EL PASO COUNTY

1/5/2018

Subject: Judge Orr RV Park – Site Development Plan – (PPR-16-040) – review #2

SHEET NO.  
**DP1**  
1 OF 7 SHEETS

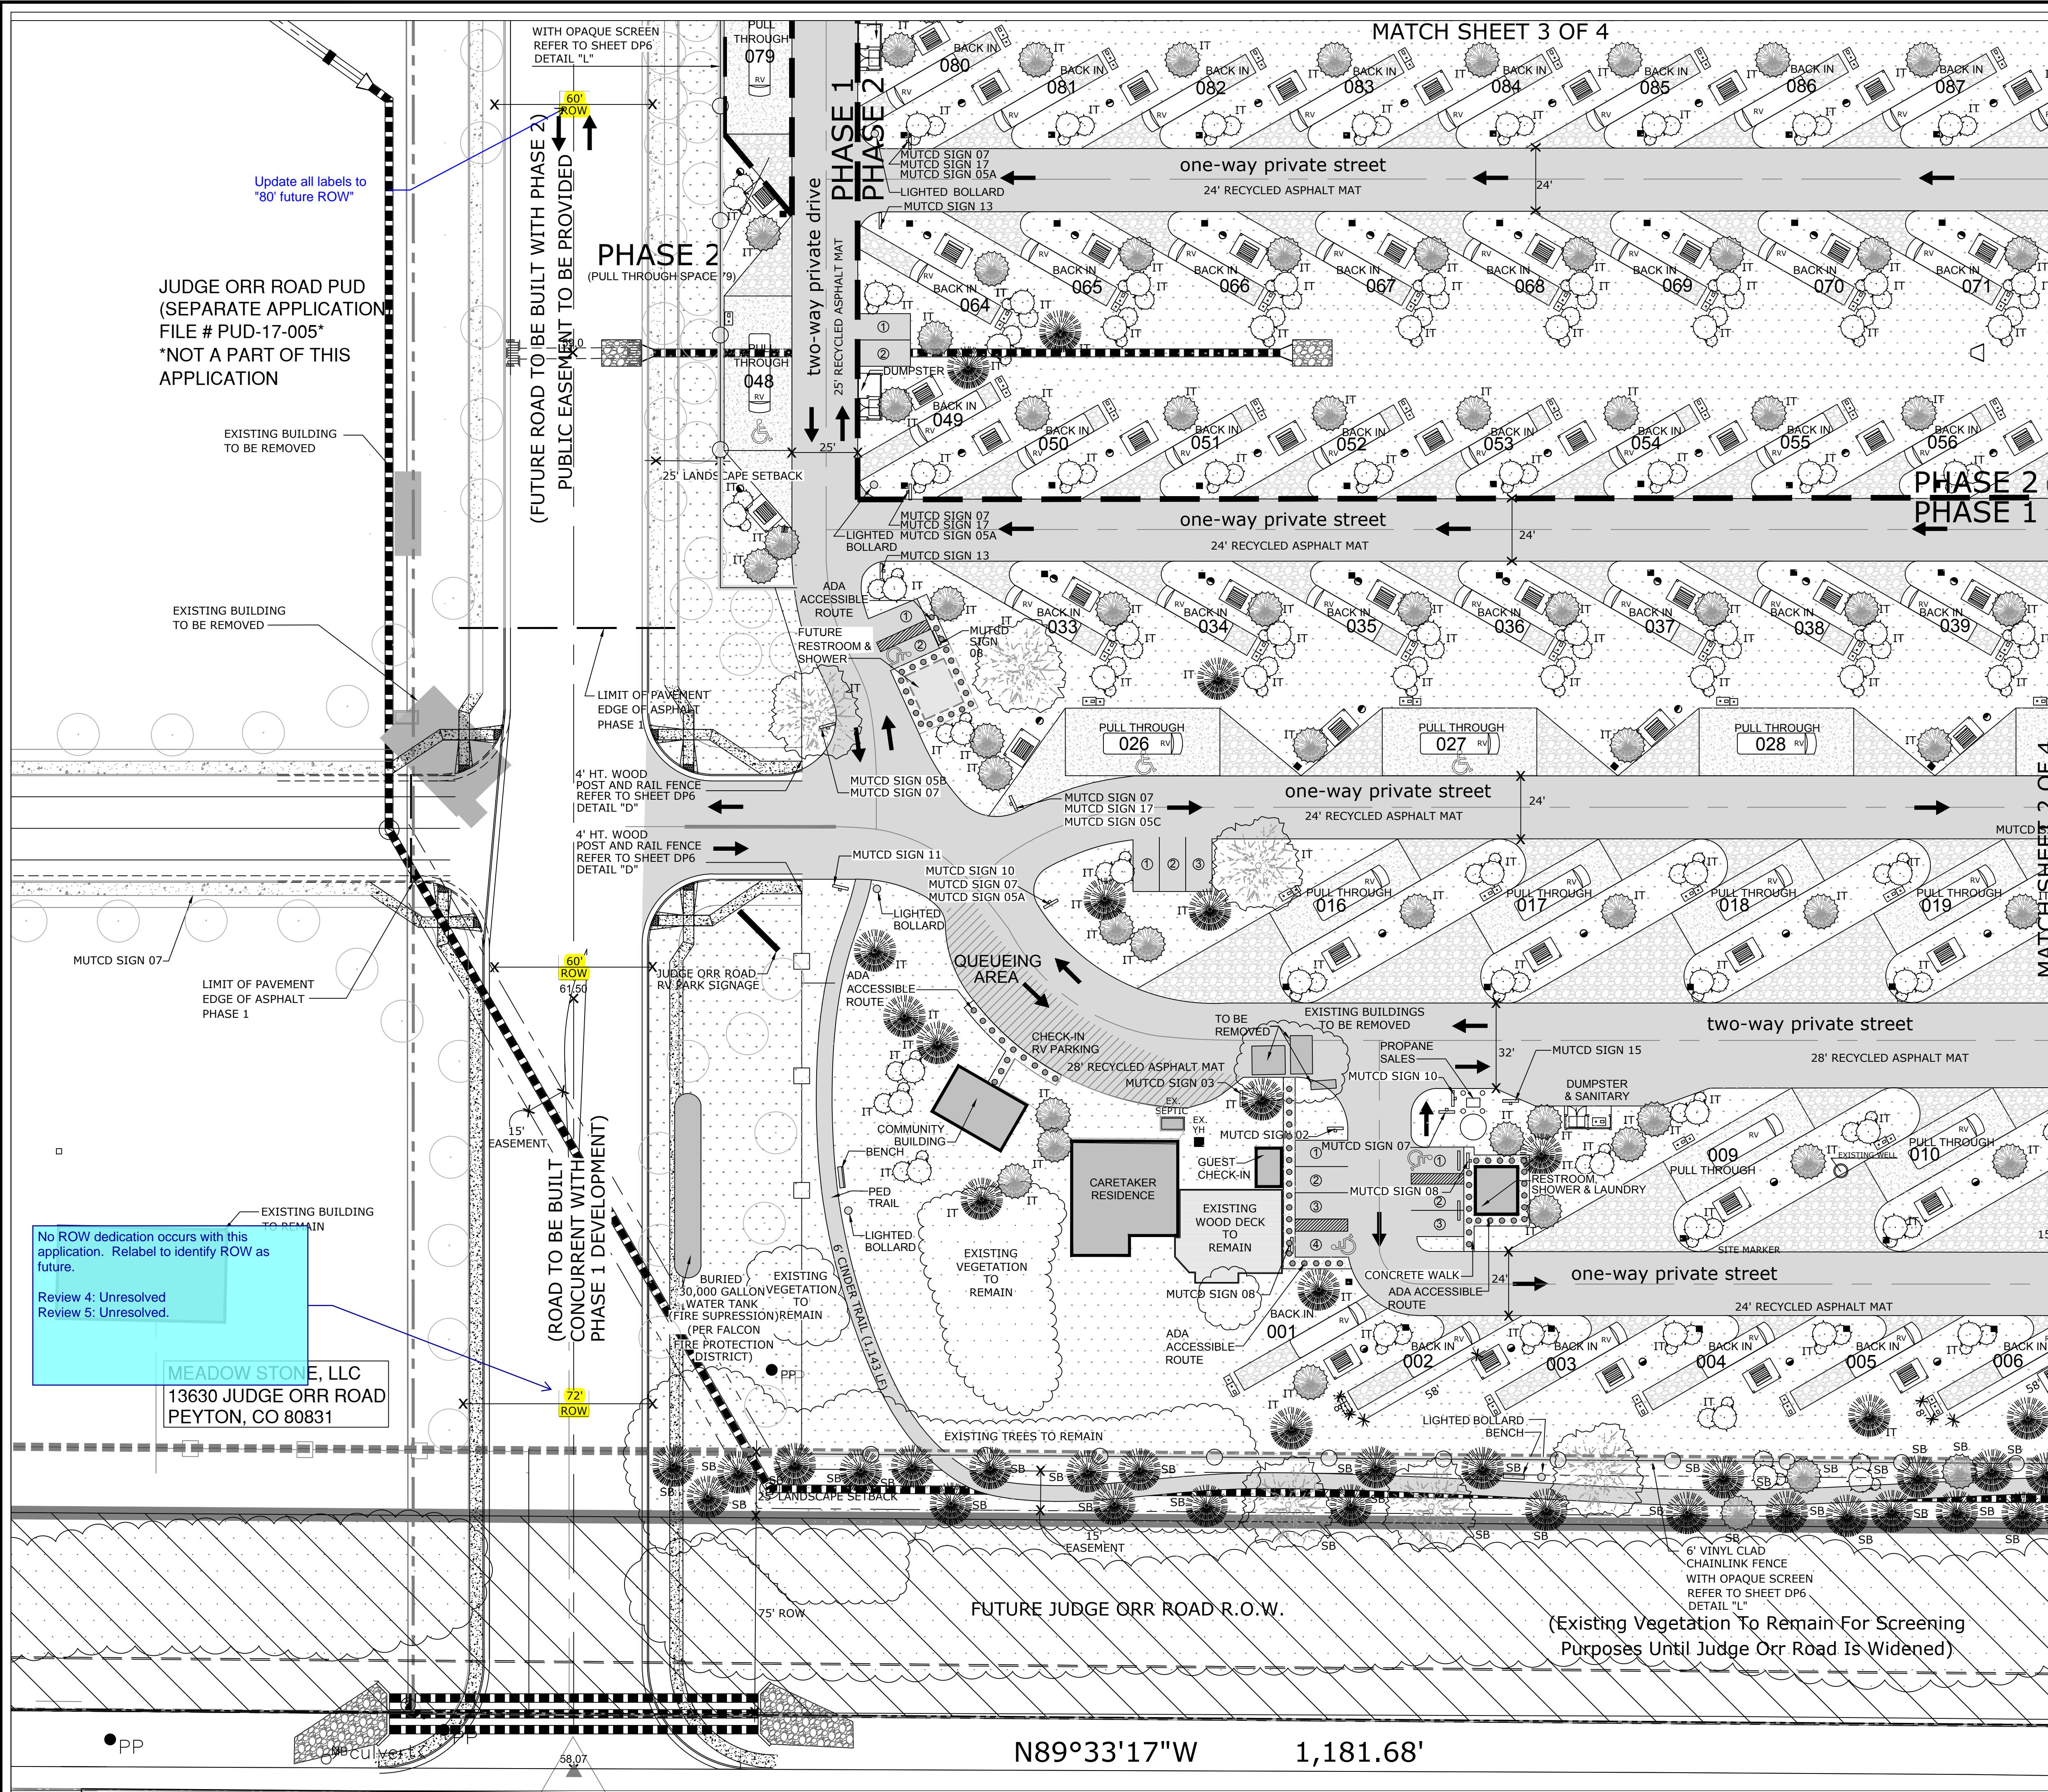
1. **Resolved**
2. **Resolved depending on response to comments below. There is no clear depiction of the phasing of the development shown on the plans.** Response provided indicates there will only be one phase. Traffic report dated 11/29/2017 (page 4) indicates that there will be multiple phases. Phase 1 is to include 50 of 170 RV camp sites will be developed along with 45 mini warehouse storage units. If this is no longer the proposed development pattern revise the traffic report to reflect the new proposal. Page 9 of the traffic report indicates the need for an eastbound left turn lane on Judge Orr is projected sometime after completion of Phase 1. Eliminating the phasing does not eliminate the

4. Identify the areas calculated as open/recreational space with an appropriate symbol or designator. Response provided indicates County clarification needed. Section 4.2.5 RVP, Recreational Vehicle Park paragraph 10 requires that 8% of the total area of a recreational vehicle park shall be set aside as open space for park users. This area may not include area reserved for service facilities, setbacks or other non-usable areas. The plan indicates 13.9 acres of open space. The comment is clear. Designate where the open space is located. The detention pond and septic field, being areas reserved for service facilities shall not be included in this calculation.

6. **Resolved. Sidewalks shown, not labeled. Main office access through “cinder trail” not sidewalk. If not the case, please clarify with label.** Sidewalks must be provided to serve accessory and recreational facilities and identified on the plans and corresponding construction documents required to be reviewed, approved, and recorded prior to approval of the site development plan for the RVP.

13. **Identify any proposed lighting associated with the RVP** Paragraph 6 of Section 4.2.8 states "Road and sidewalks shall be adequately lighted, in conformance with Chapter 6..." See Section 6.2.3 (Page 6-16) for lighting requirements.

14. **The symbology used for the chain link fencing and the split rail are the same. Revise accordingly.** The symbology looks the same in the data tables and is indistinguishable as unique on the plan drawing. Please utilize distinctly different symbols.

17. **Resolved. A detail has been provided for tent camping sites, but none appear to be located on the plan.**
18. **Not Resolved. The existing building to be used as the office appears to be located over the western property boundary. Revise as necessary.** Response provided "this is correctly indicated, owner(s) may explain." Structures straddling property lines are problematic. How will this issue be resolved? Boundary line adjustment?

21. **Table 4.6 (Page 4-14) clearly indicates that the required setbacks from RV to RV is 20 feet. Pad details indicate a setback of 10 feet. This plan will need to be revised**

- to indicate the correct setback or relief will have to be requested. Alternatively, provide documentation that a reduction of the setback by 50% has been provided.

22. Remove General Notes 1, 2, 3, 4 and 5. Once the site development plan is approved the expectation is that the site will be built as approved. An amendment to an approved site development plan will be required to accommodate changes.

23. Be advised that notes on the approved plan are subject to enforcement by El Paso County. For instance Note 11 gives the County the right and responsibility to measure the mounded height of the medians and lot islands. Mounded heights of less than 24" are then an enforceable item. Recommend removing notes such as this from the plan. This is the same for the Landscape Notes. General Notes and Landscape Notes are not required on a Site Development Plan. The recommendation is that all General Notes and Landscape Notes be removed.

SHEET NO. **DP3** 3 OF 7 SHEETS

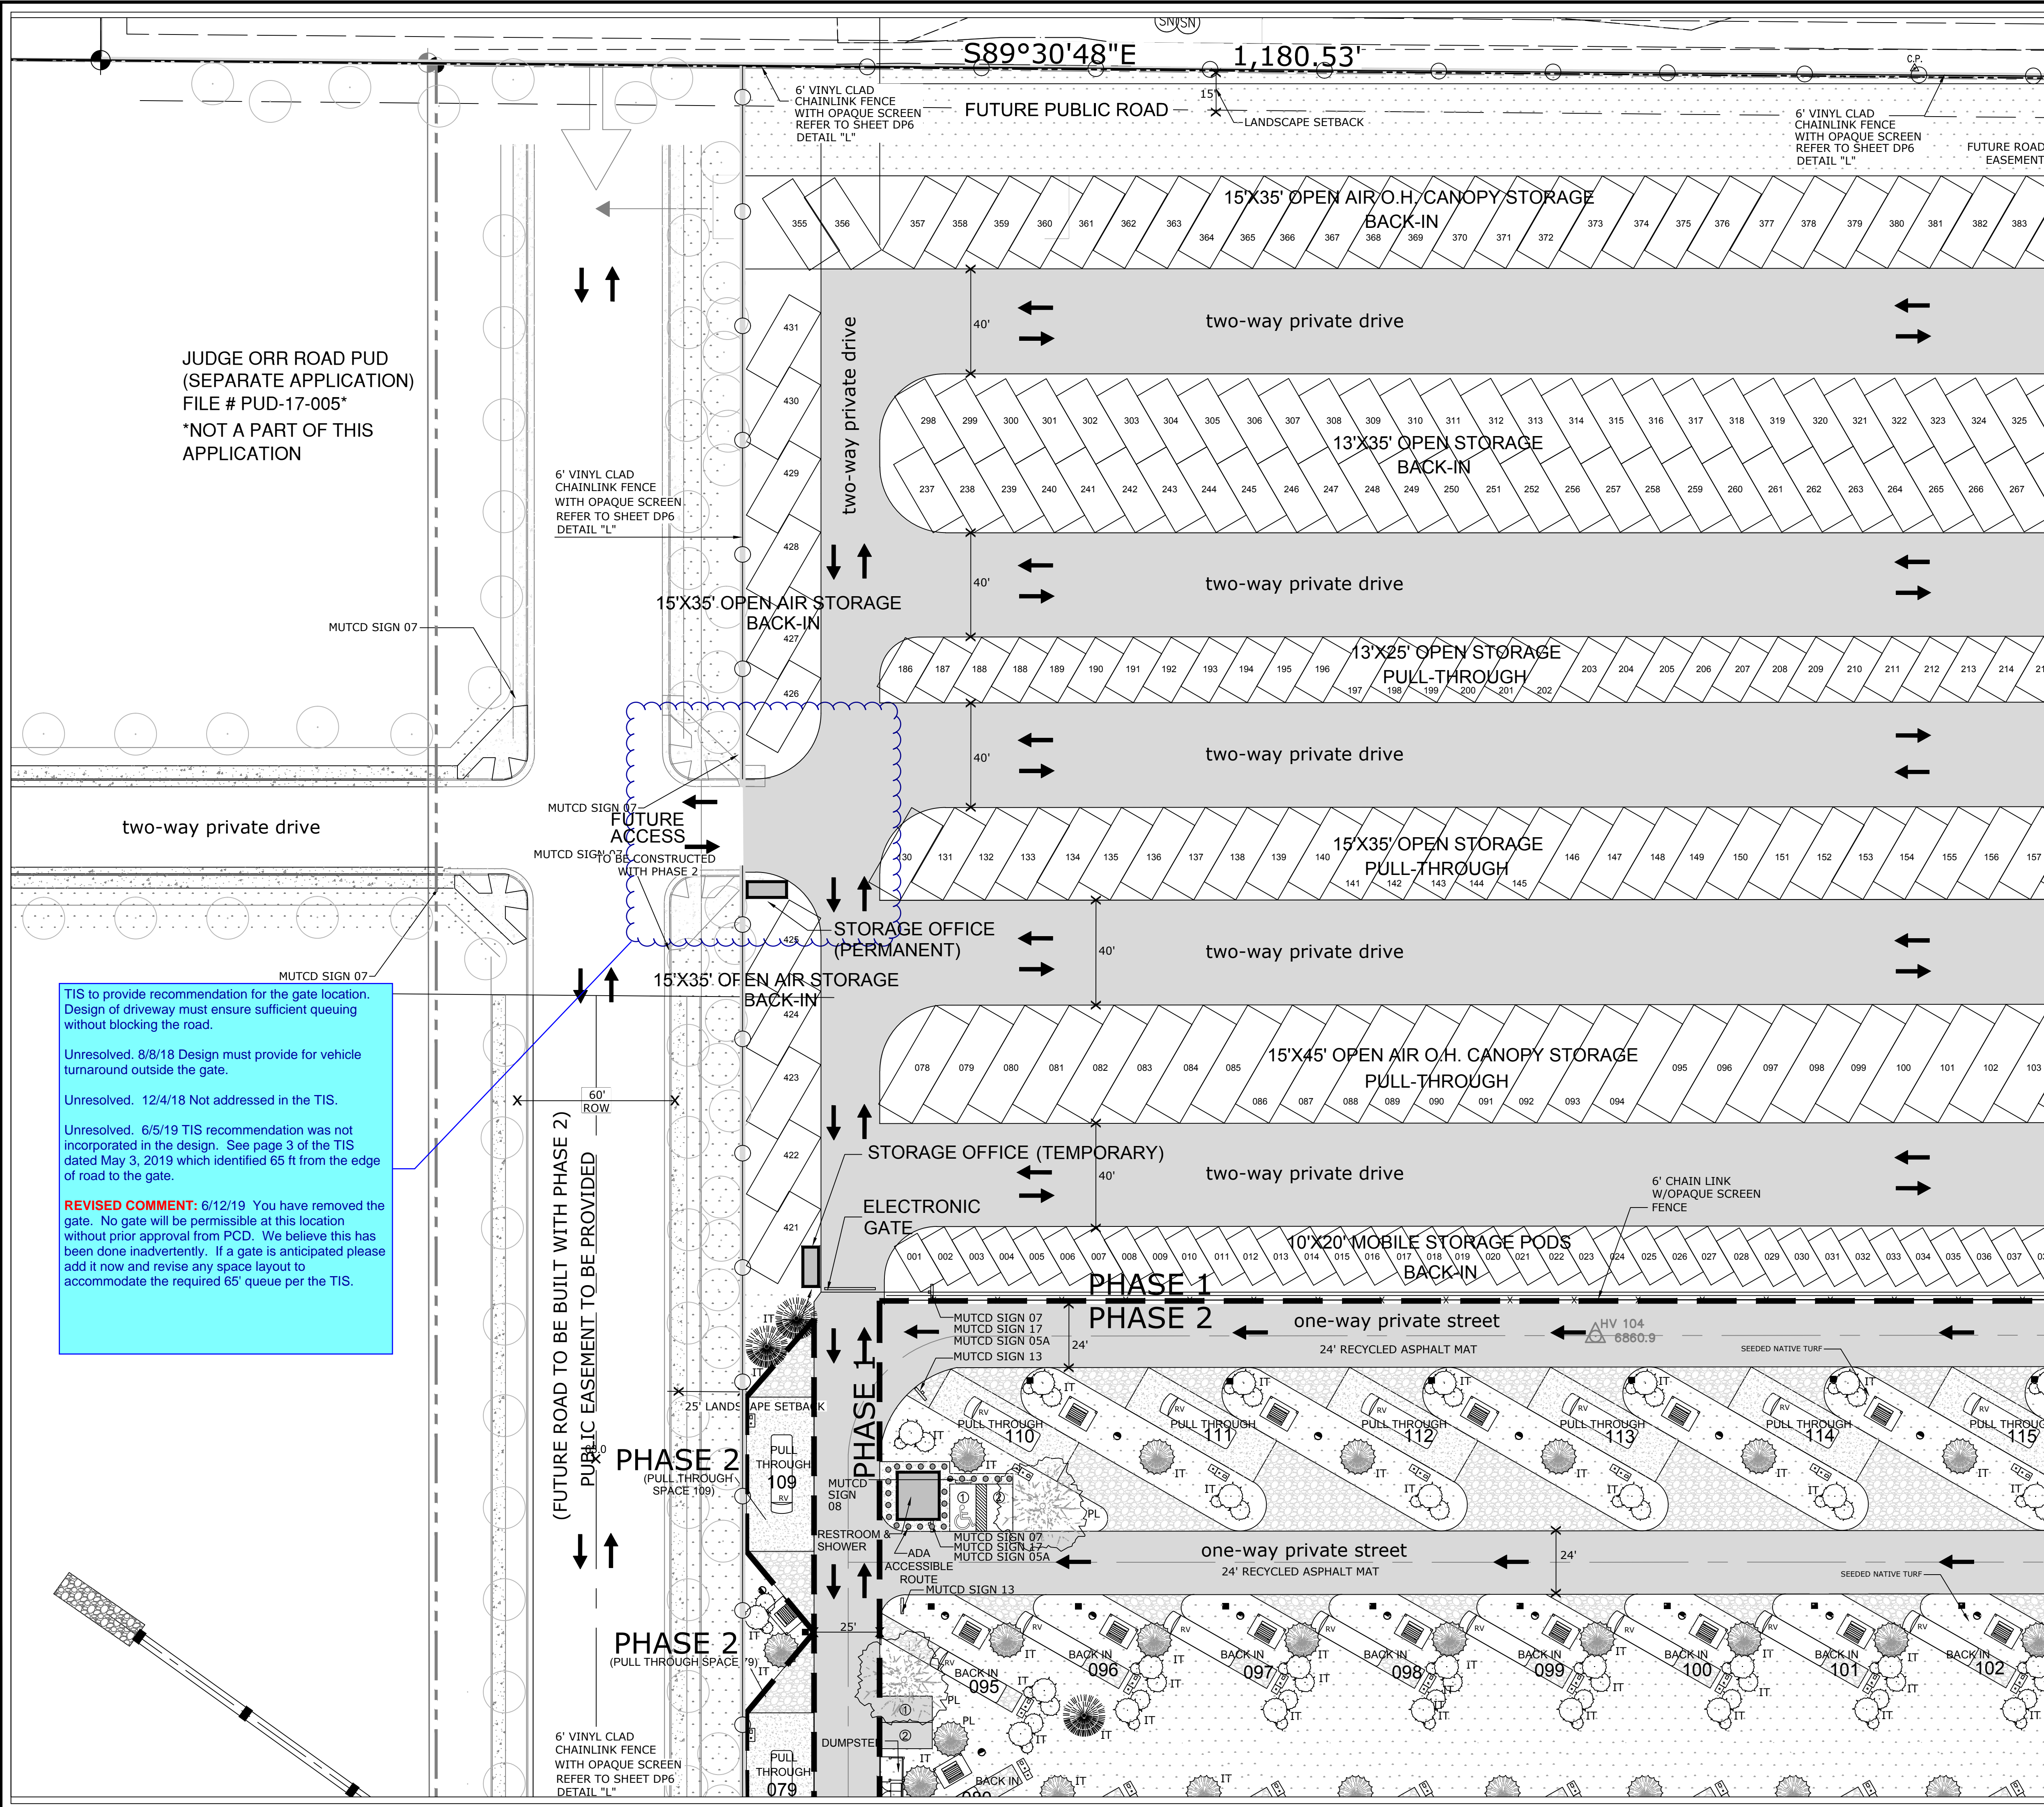
8. **Resolved. The required landscape counts have not been met for the zoning district boundary categories (1 tree/30 feet of property line), unless, an alternate plan is being proposed to locate required landscaping outside of the landscape setback to have a better effect of screening against some areas. Please provide clarification in the letter of intent and request approval of an alternate plan for that purpose. Also, the proposed fencing with slats has not proven to provide adequate opaque screening, nor been found to be durable under weather conditions. An acceptable form of screening would be an opaque mesh treatment for the chain link fencing.** Submit a complete landscape plan with the next submittal that meets the requirements of the Code. Specifically, Landscaping shall be in conformance with the requirements of Chapter 6. The boundary of the recreational vehicle park shall be buffered with, landscaping, hedges, evergreens, shrubbery or a 6-foot screening wall or fence installed to serve as a buffer from adjacent property. The landscaping, fences, or walls and adjacent setback areas shall be privately owned, constructed and maintained.
